### **Application by AQUIND Limited for an Order granting Development Consent for the AQUIND Interconnector Project**

#### **Agenda for Issue Specific Hearing 3 dealing with Environmental Matters (ISH3)**

<b>Title of meeting</b>	AQUIND Interconnector Issue Specific Hearing on Environmental Matters
<b>Date</b>	15 December 2020
<b>Time</b>	10.00 am
<b>Venue</b>	Online via Microsoft Teams invitation
<b>Attendees</b>	Invitees

TITLE: **Figure 24.2
Key plan
Sheet 0 of 15**

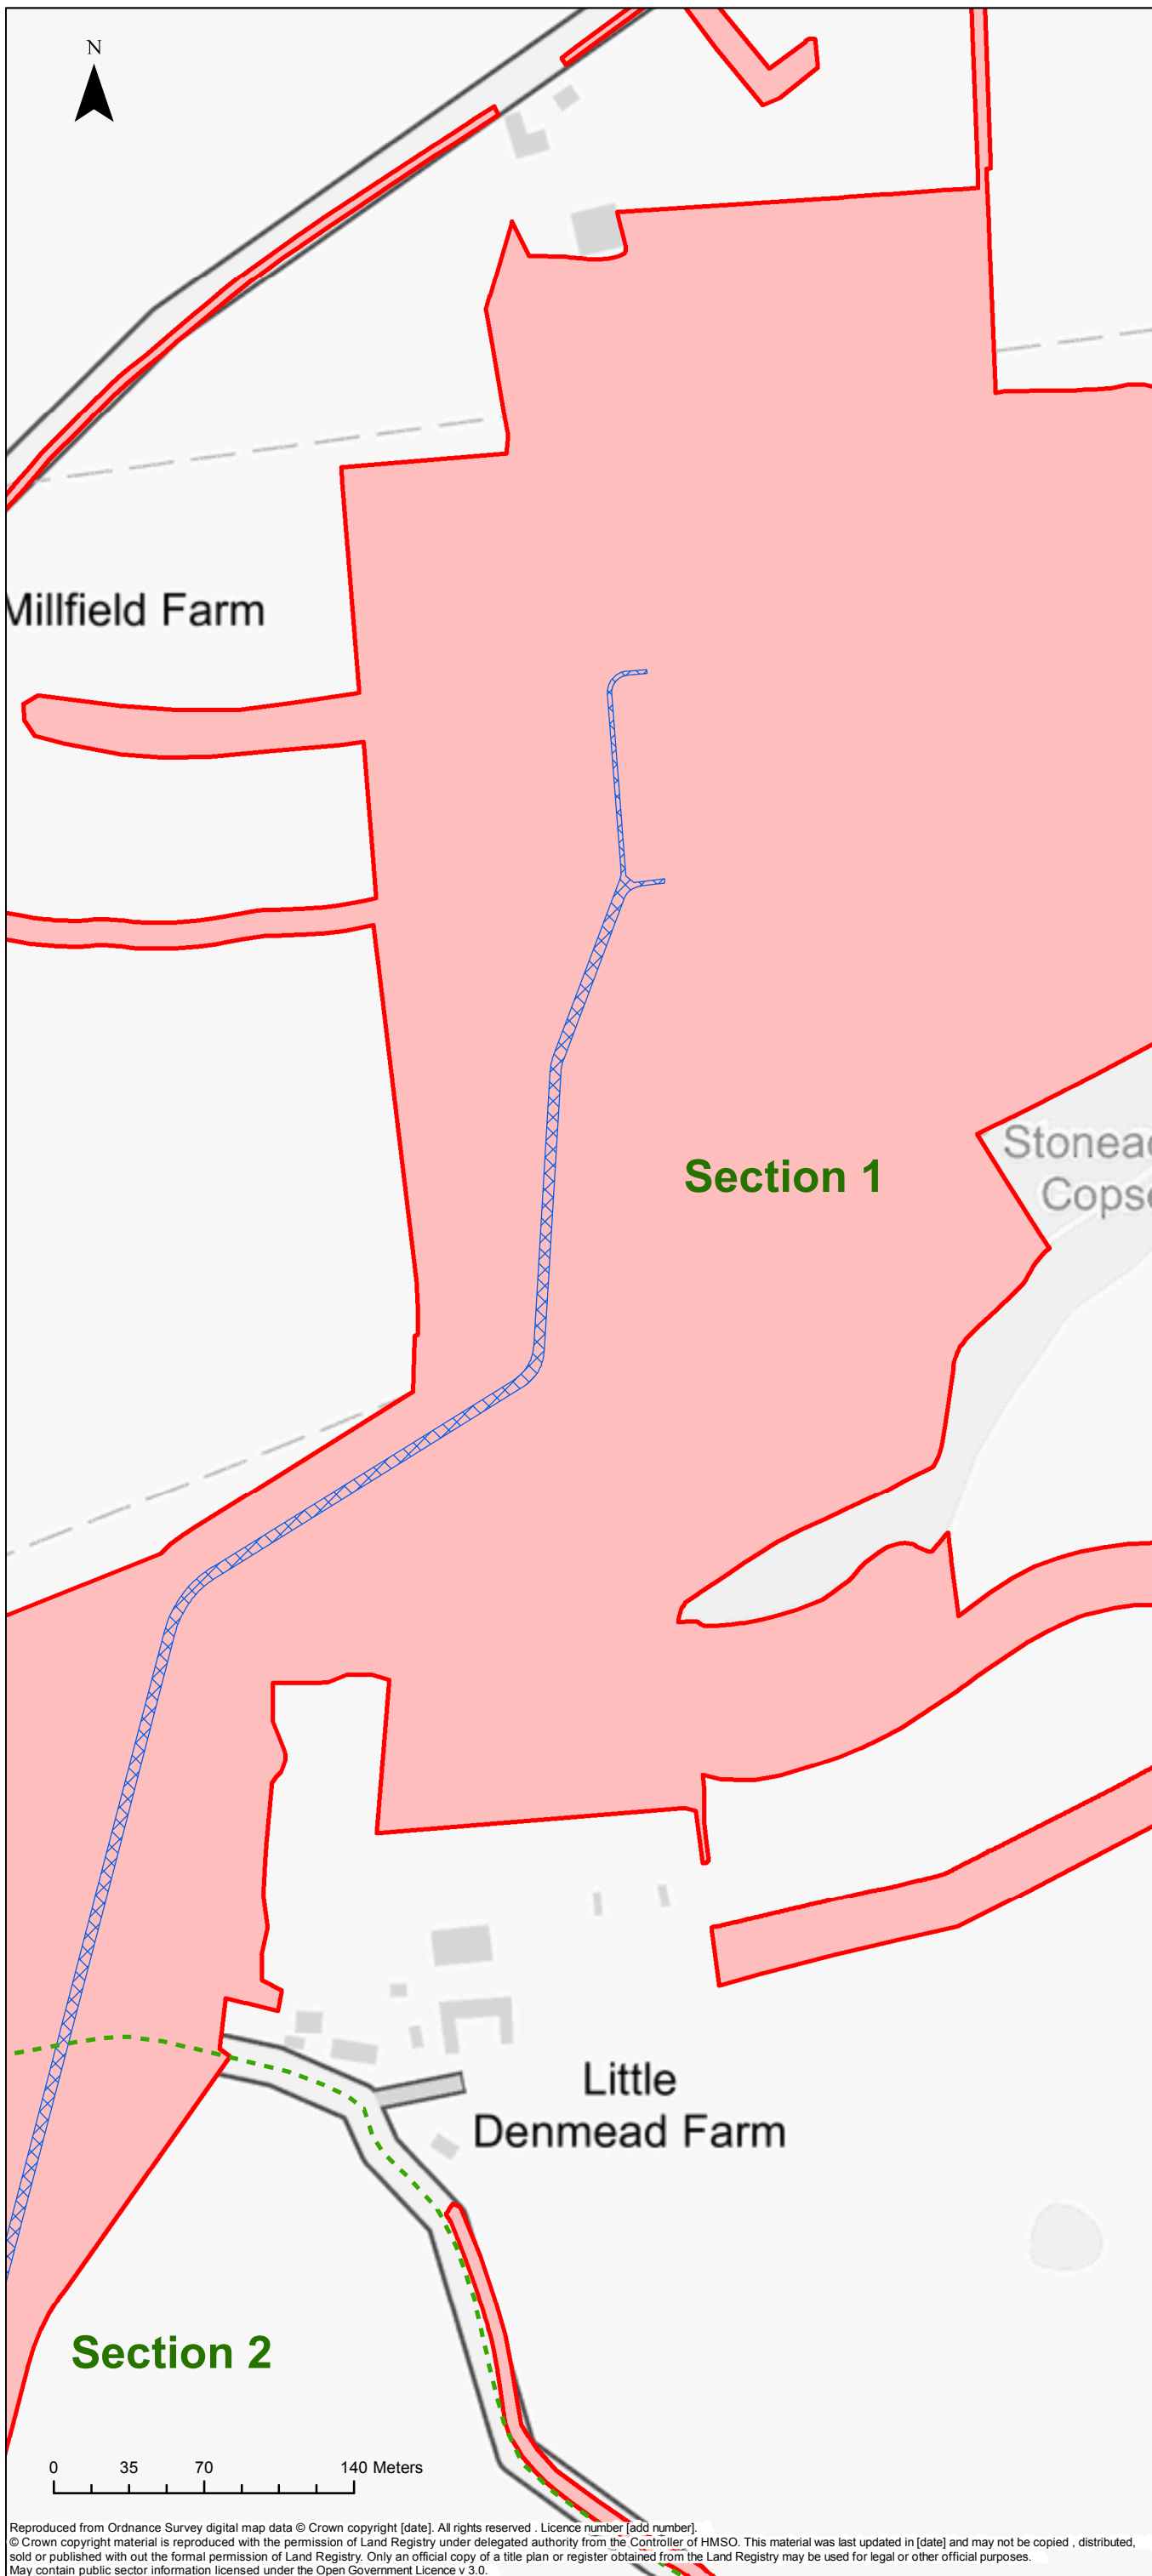
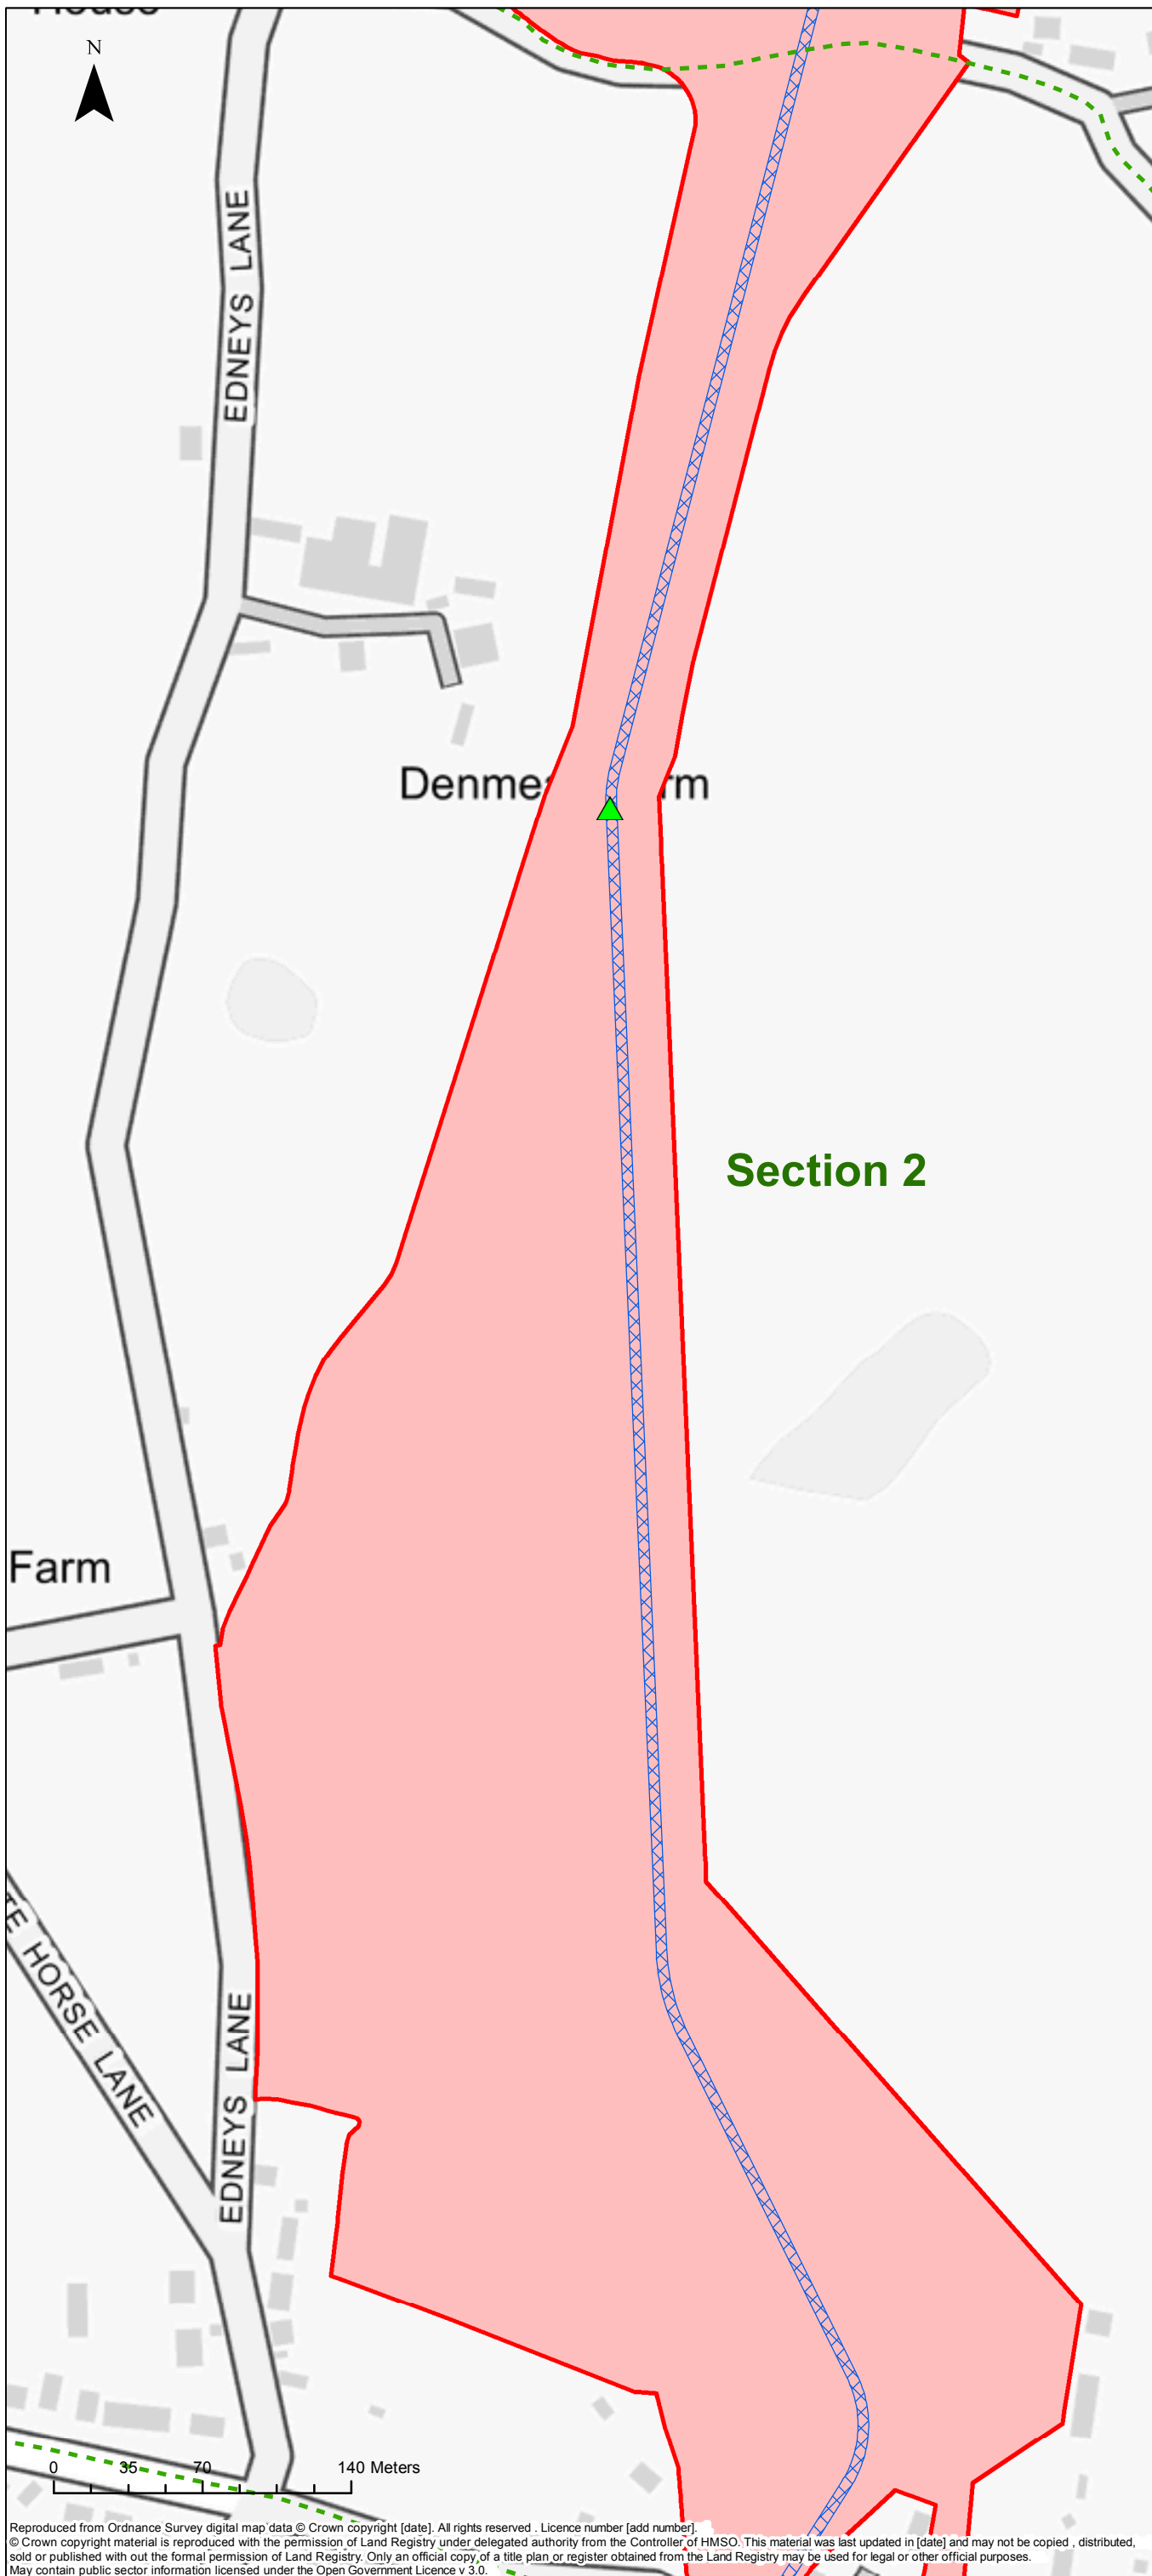
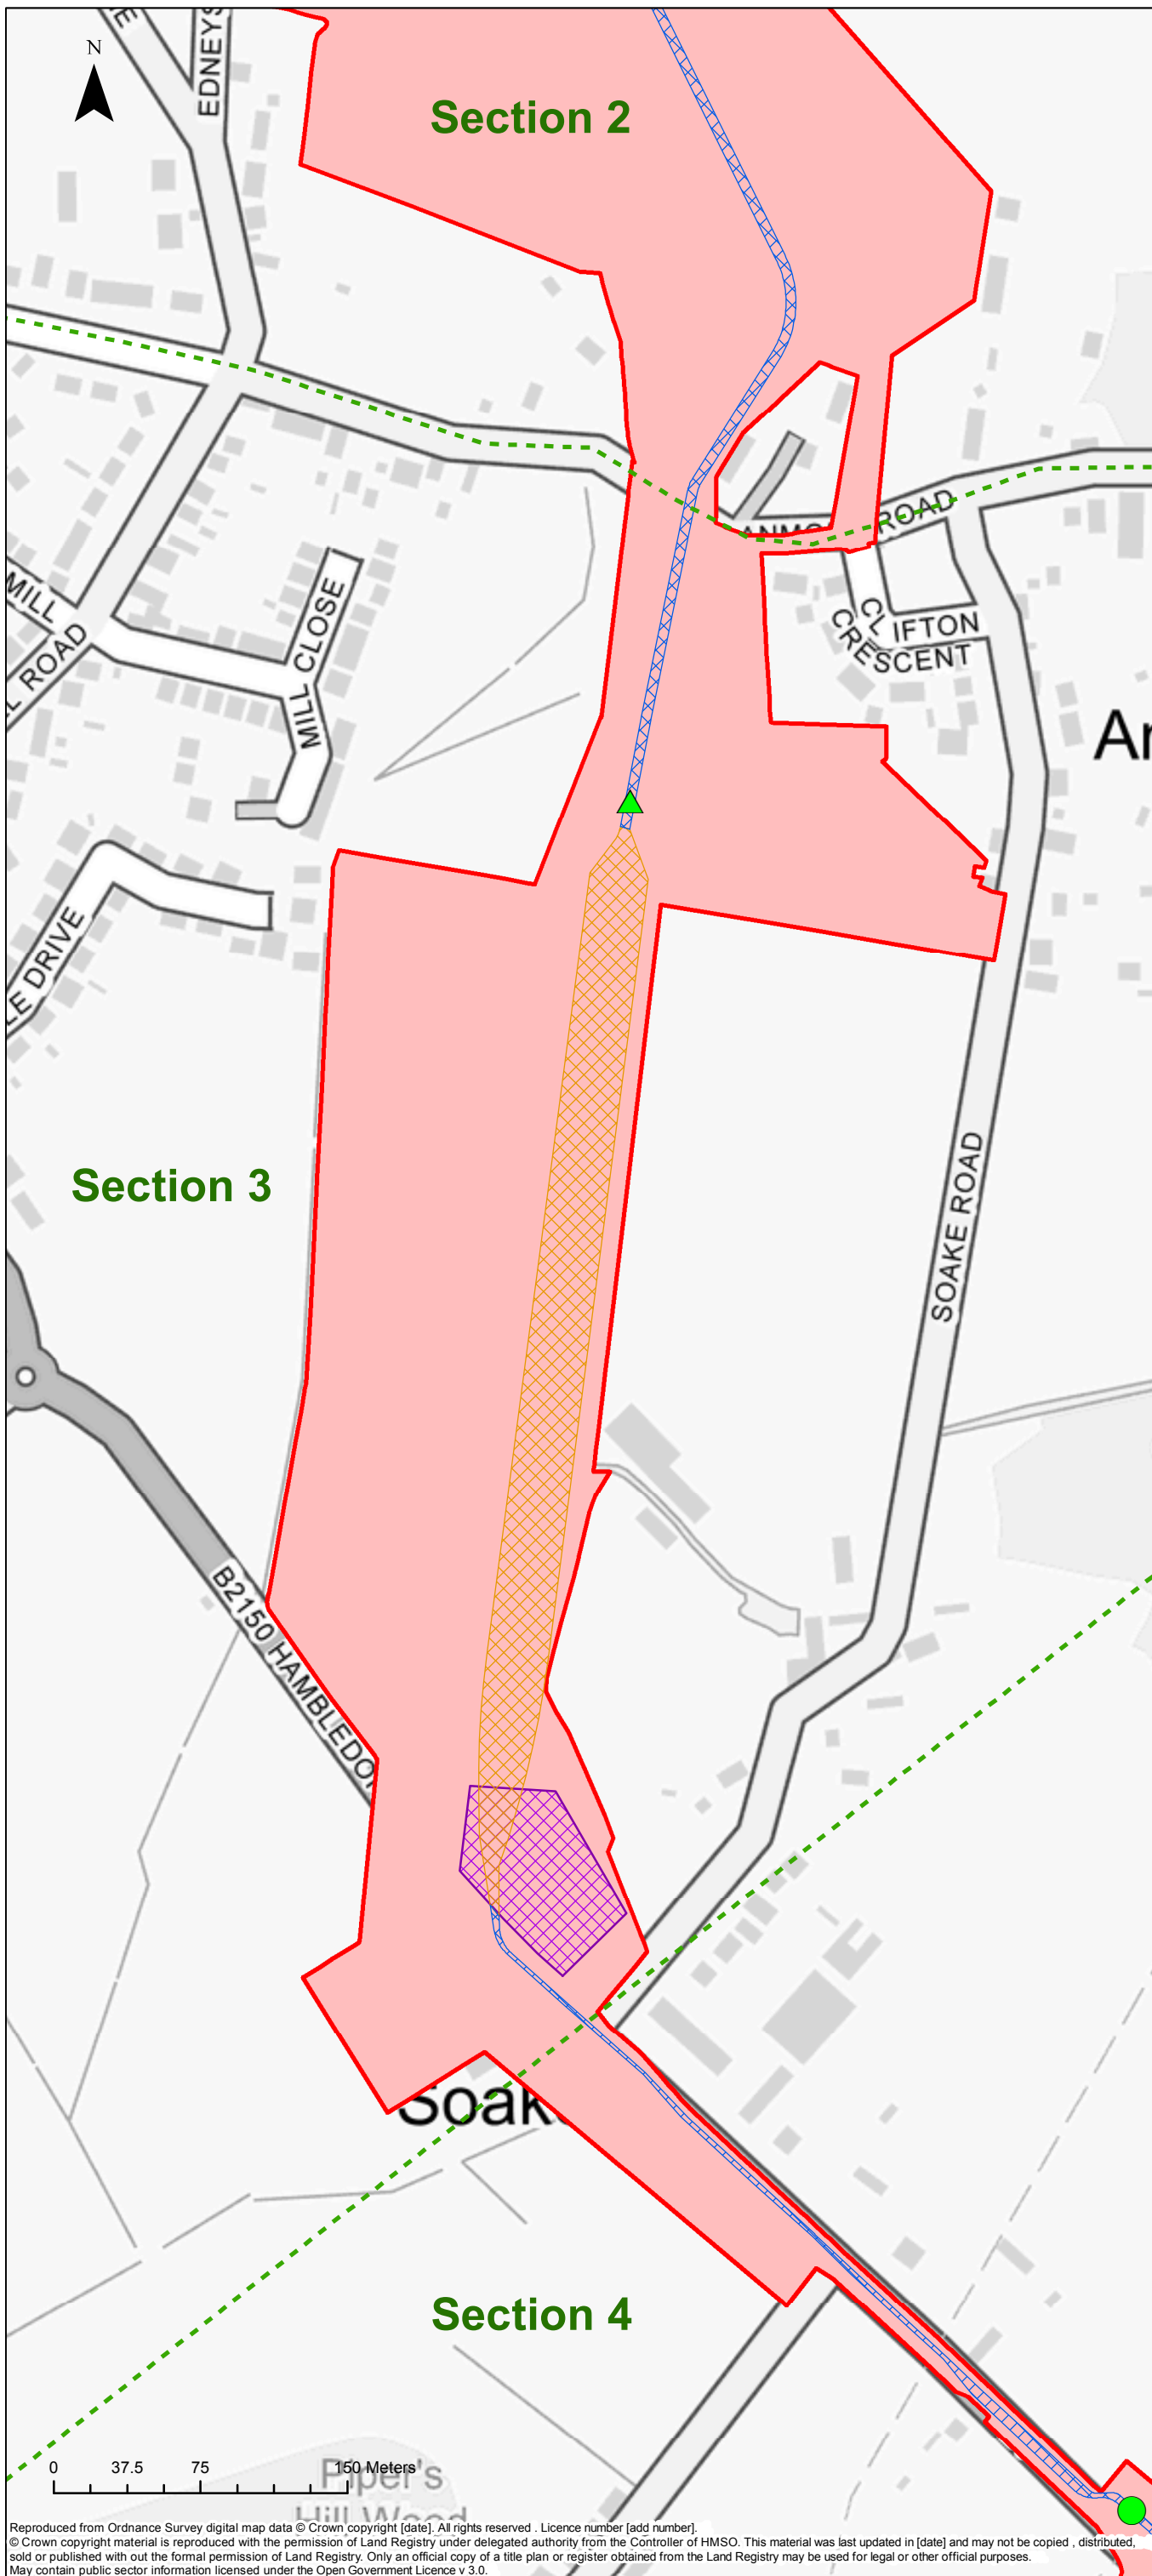
- With reference to ExQ1 N1.11.3, could the Applicant clarify the meaning of its response: *'Within the onshore cable corridor, the relative distance between the illustrative cable route and the noise sensitive receptors influences the magnitude of noise level experienced by any receptor. The magnitude of impact and overall noise effect assigned to this magnitude of level is influenced by the duration, timing and frequency of exposure to that noise level, which is not altered by the alignment of the cable route.'* The first part suggests that the distance between the cable installation and a receptor does influence the impact perceived at the receptor, as might intuitively be expected as noise diminishes with distance from source. The second part could be taken to contradict this. Notwithstanding the ultimate judgement of whether such an impact is significant or not, could ExQ1 N1.11.3 be reconsidered in respect of the different effects that might be perceived at sensitive receptors near those stretches of the route where it would be possible for installation to come substantially closer than the illustrative route?

- How robust is the assessment of magnitude of change in the noise environment and the determination of significance in the light of this? How does it relate to the adopted EIA approach of assessing the worst case?
